Town and Country Planning Act 1990 (as amended)

APPLICATION NO: 24/00168/FUL/ADDINF
DESCRIPTION: Relocation of extractor flue and new shop front.
LOCATION: 3 Rectory Row Rectory Lane Bracknell

SITE LOCATION PLAN
AREA 2 HA
SCALE 1:1250 on A4
CENTRE COORDINATES: 486646, 167976

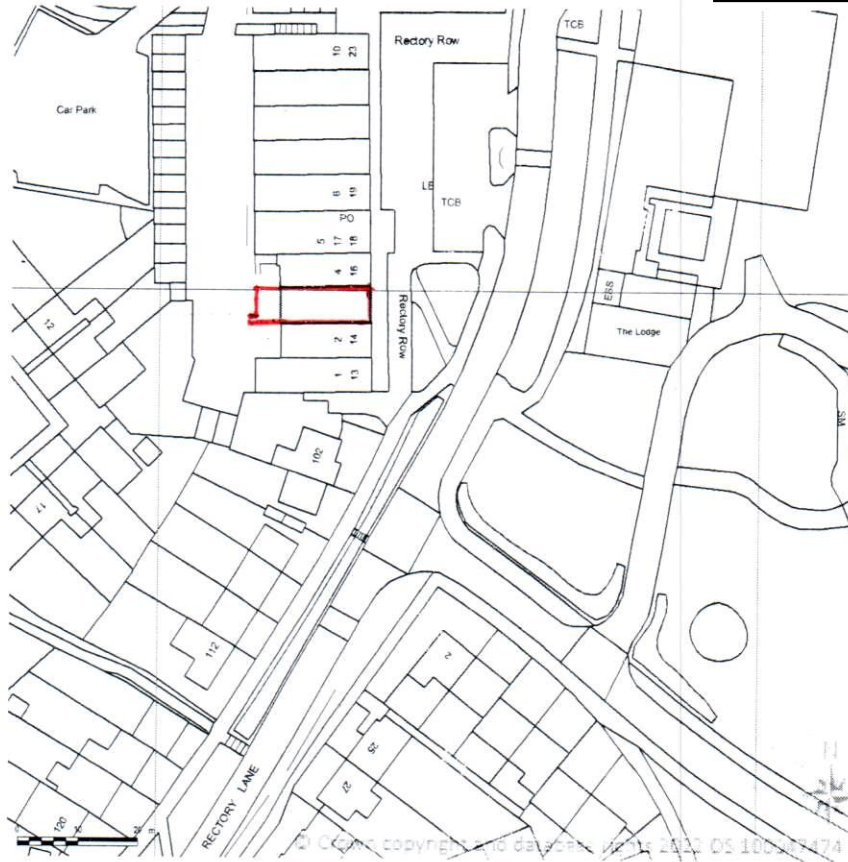
- 1 Please extend the red line on the site location plan to include the extension site.
- 2 Please provide a block plan at the scale of 1:200 or 1:500.
- 3 Please complete Certificate B on the application form and serve notice on the owner of the building.
- 4 Do not submit this additional information through the planning portal. Please email directly to myself.
